# **HINCKLEY NATIONAL RAIL FREIGHT INTERCHANGE**

## **Stage 1 Road Safety Audits and Response Report (Local Road Network)**

Document reference: 21.1.1

RESPONSE REPORT

Proposed Layout - School buses waiting in loading bay in front of Co-Op

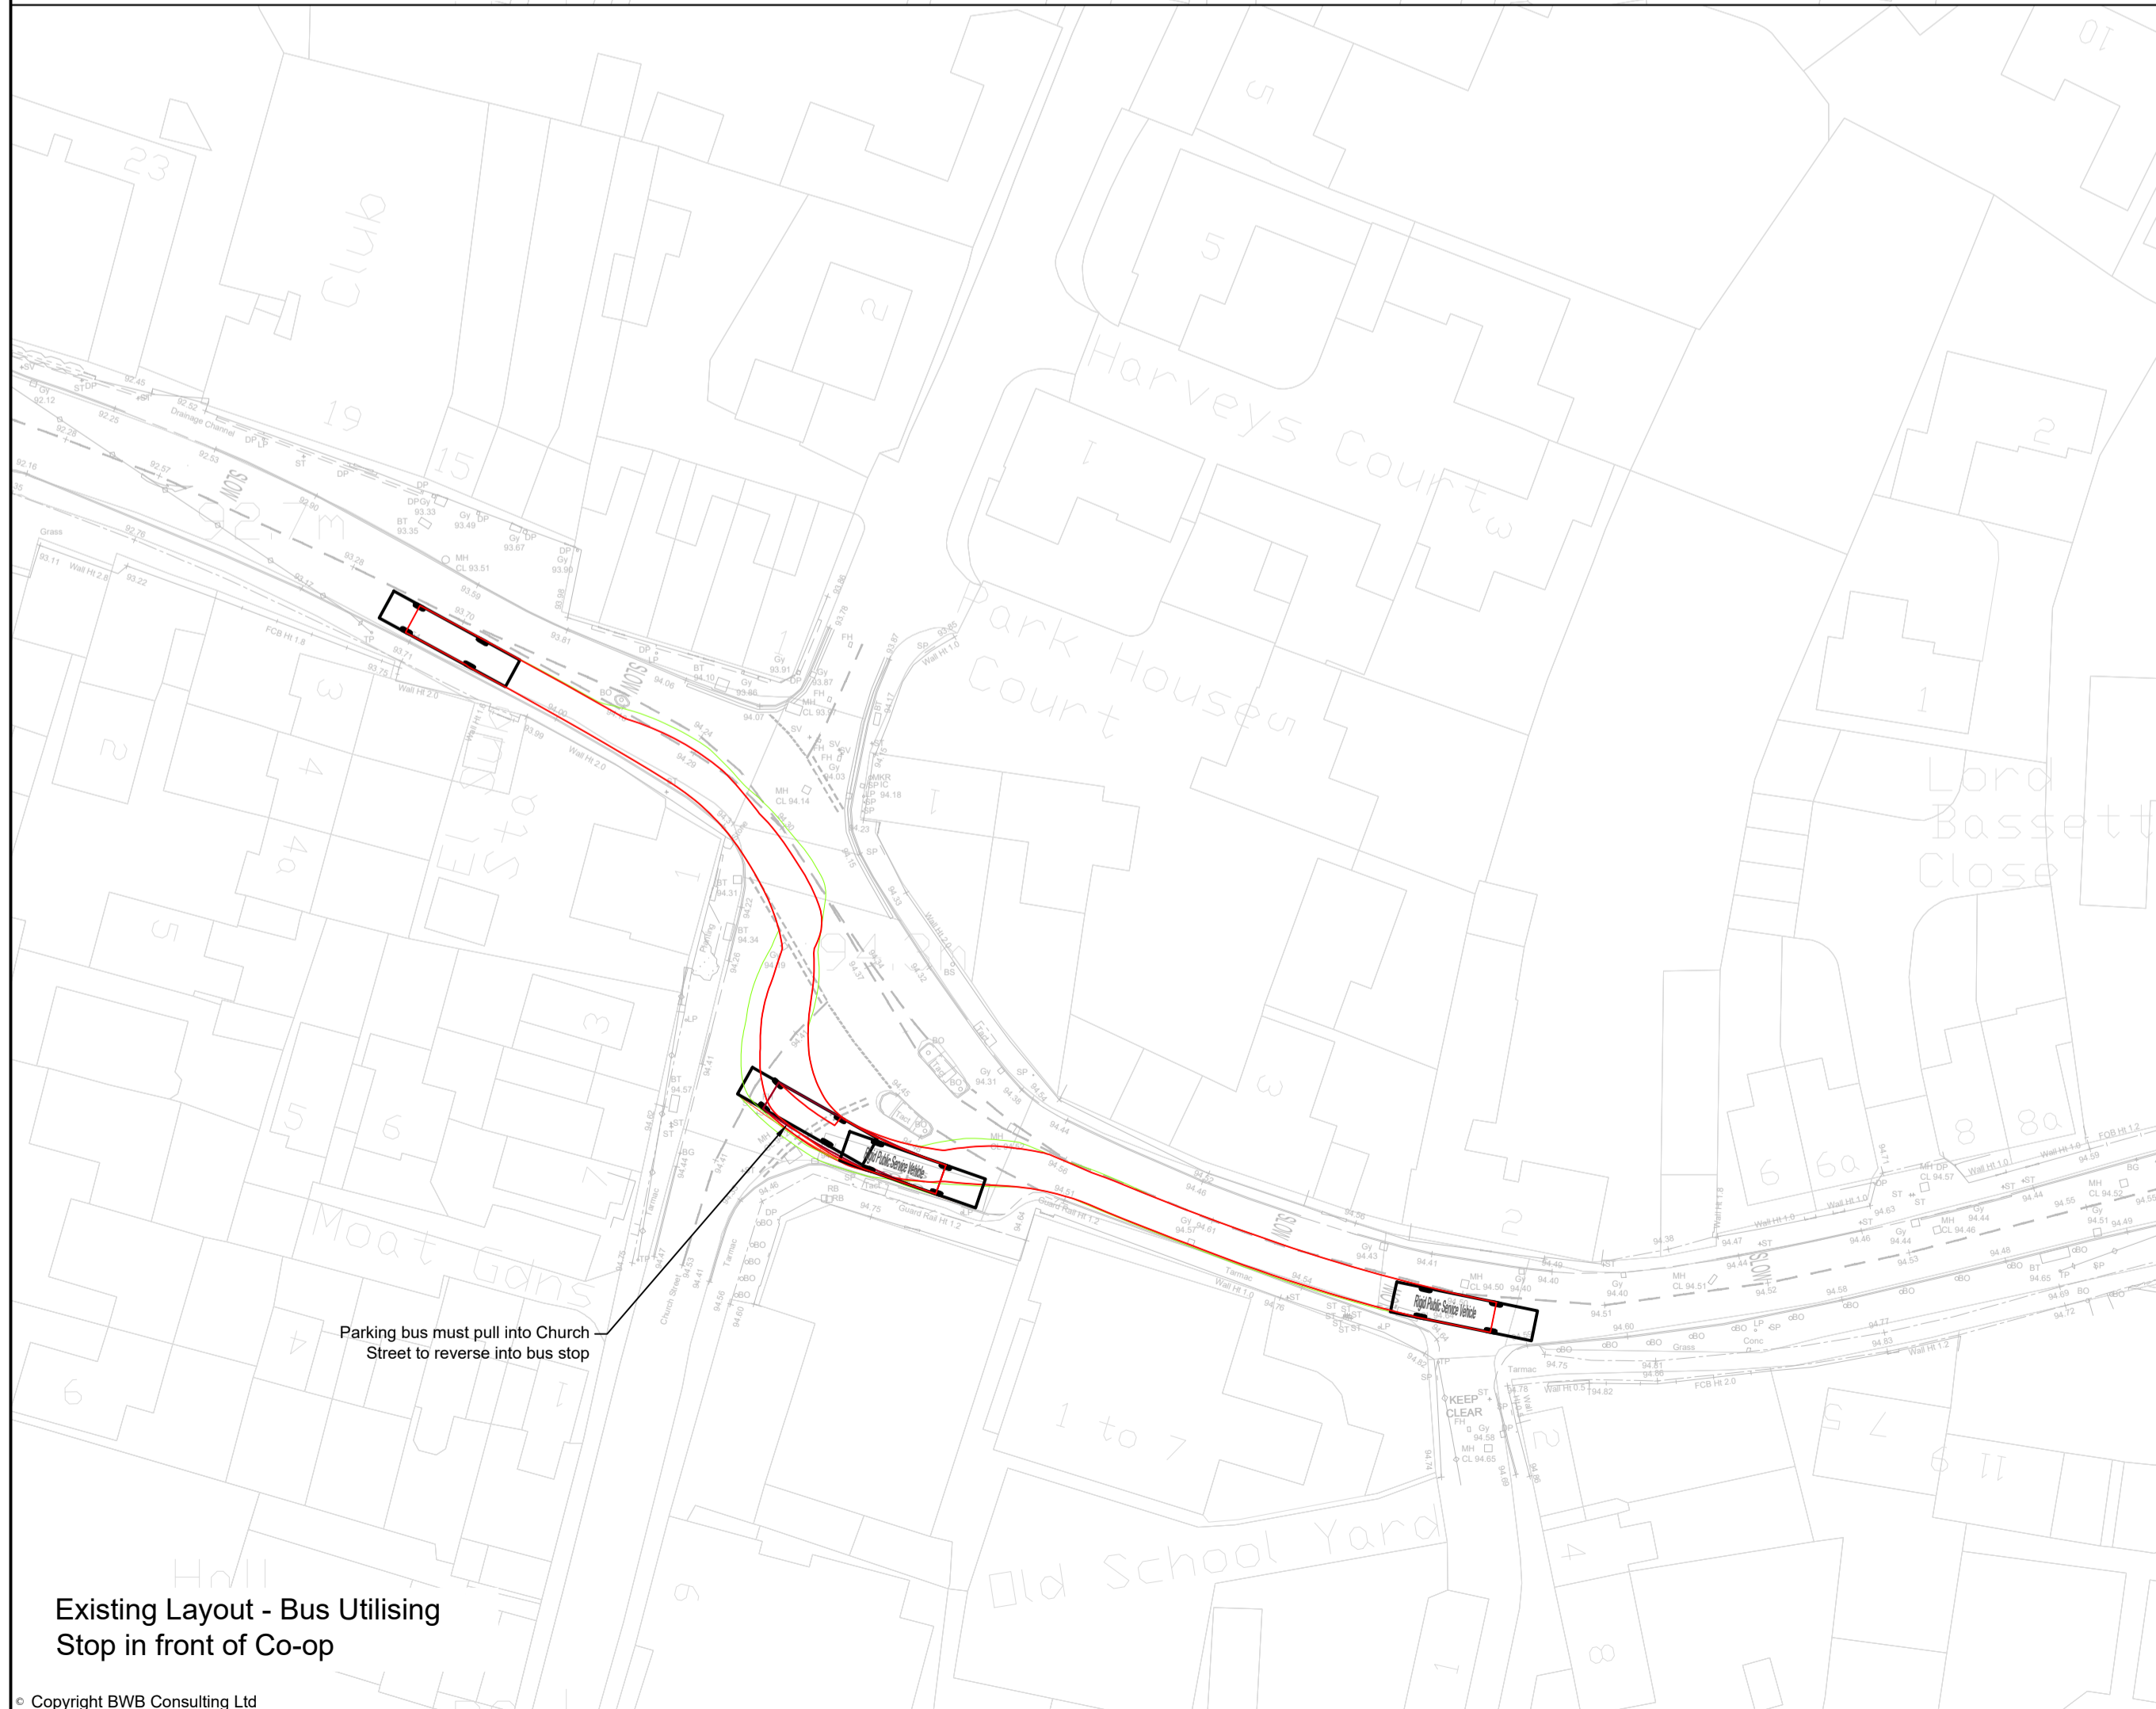
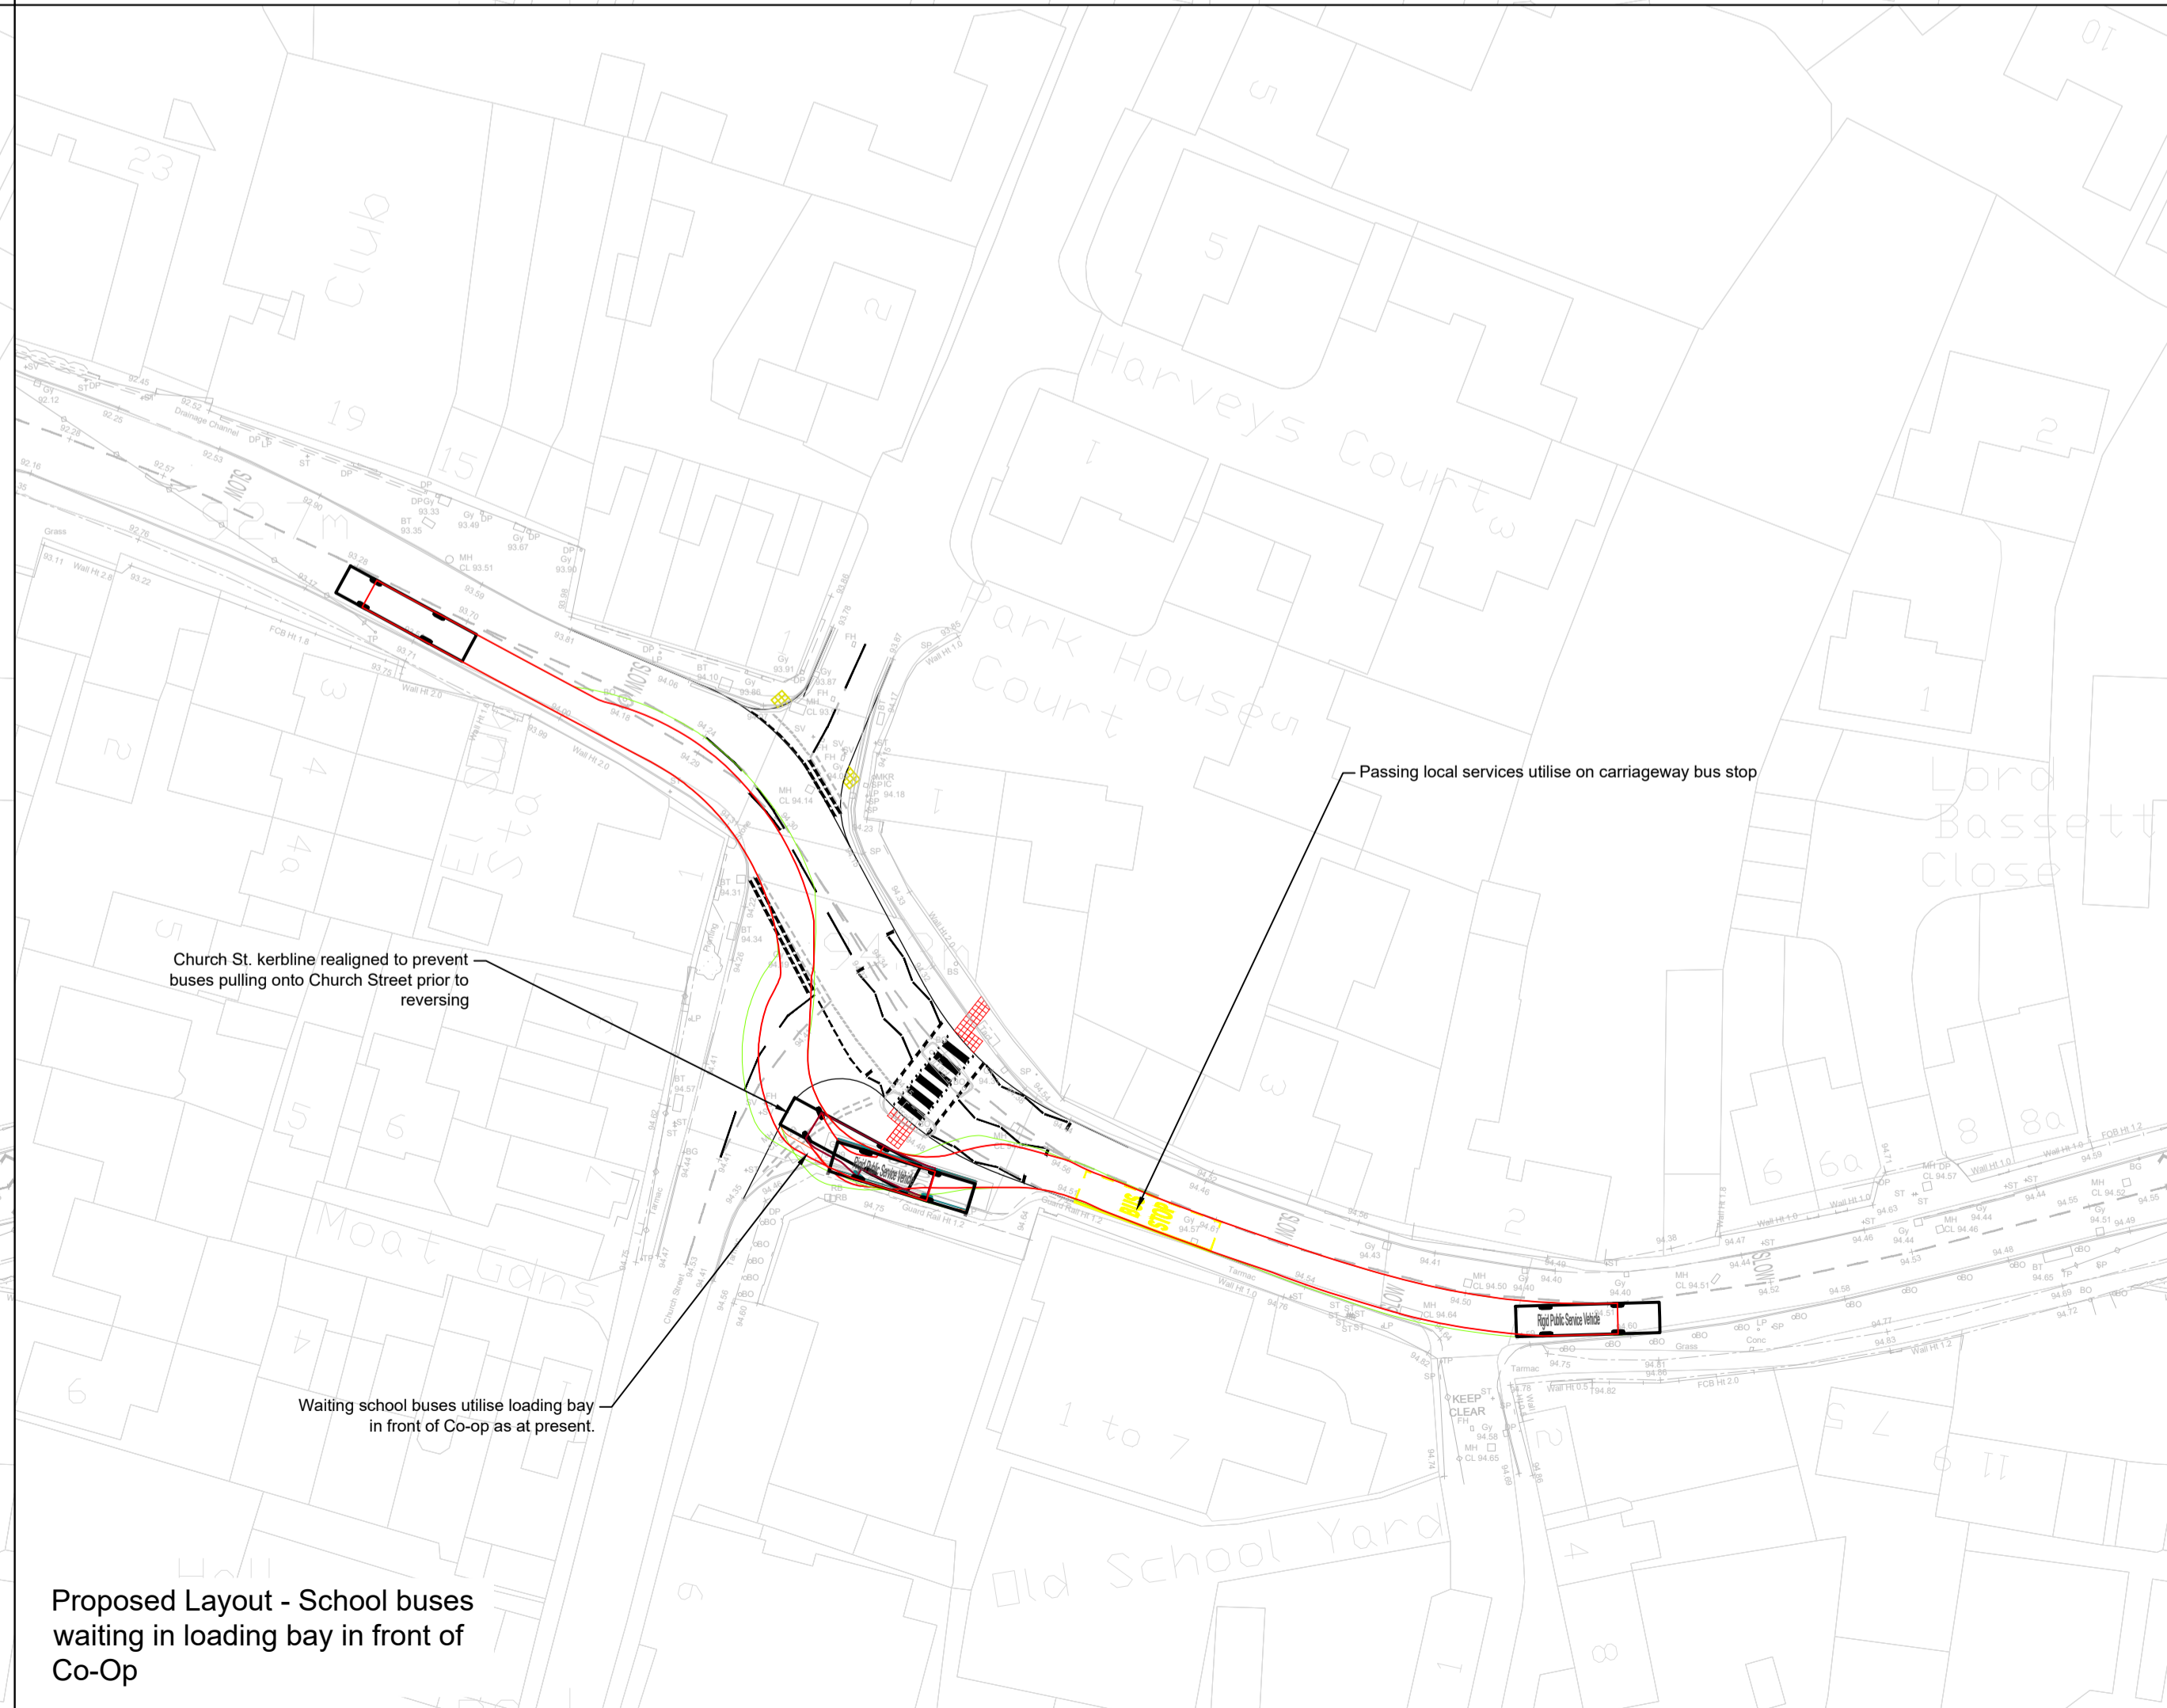
RSA Ref.	RSA Problem and Recommendation	Design organisation response	Overseeing organisation response	Agreed RSA action
	<p>Location: Leicester Road - proposed bus stop / loading bay within "shared space" footway.            Summary: School bus movements within the footway risk vehicle to pedestrian collisions.</p> <p>Under the existing layout school buses and delivery vehicles are able to pull into the lay-by in front of the Co-op. Whilst the intention is to maintain this existing situation, the changes to the layout here mean that the current lay-by will effectively become (and resemble) footway. This change is likely to result in pedestrians, specifically school children, waiting over a wider area as opposed to being concentrated within the footway when waiting for and alighting from the school bus. There is a concern that this will increase the risk of vehicle to pedestrian collisions, particularly given the complex manoeuvre required to fully enter the bay.</p> <p>Recommendation:            It is recommended that an alternative route / provision is created for the school bus stop/loading bay which may require a wider and more considered approach and not one that simply attempts to mirror existing circumstances.</p>	<p>Agree with RSA recommendation: In Part</p> <p>The designer agrees that careful consideration is required regarding the demarcation of any shared surface in this area with suitable tactile and contrasting coloured paving to clearly identify the areas for vehicle use.</p> <p>The Co-op have a service area in their car park on Church Street but the designer were advised by the overseeing organisation that this area is currently used by vehicles servicing the Co-op. It should be noted that it is contrary to traffic regulations for service vehicles to use the existing bus stop, however provision was made in the proposed design, utilising shared surfacing for the delivery vehicle to use this areas in the event that the overseeing organisation elects to amend the relevant traffic regulations.</p> <p>While the majority of passing bus services will use the on carriageway stop (provided on the B4669 as part of the HNRFI works), the overseeing organisation also advised that school bus services currently stop in this area. The swept path movement for buses using the area will be the same as it is currently as the area available is the same. It is the designer's view that the careful use of tactile paving, small kerb upstands and contrasting paving in this location can enable the area to be utilised successfully as a shared surface and to allow buses and school children to wait safely without coming into conflict with each other.</p>
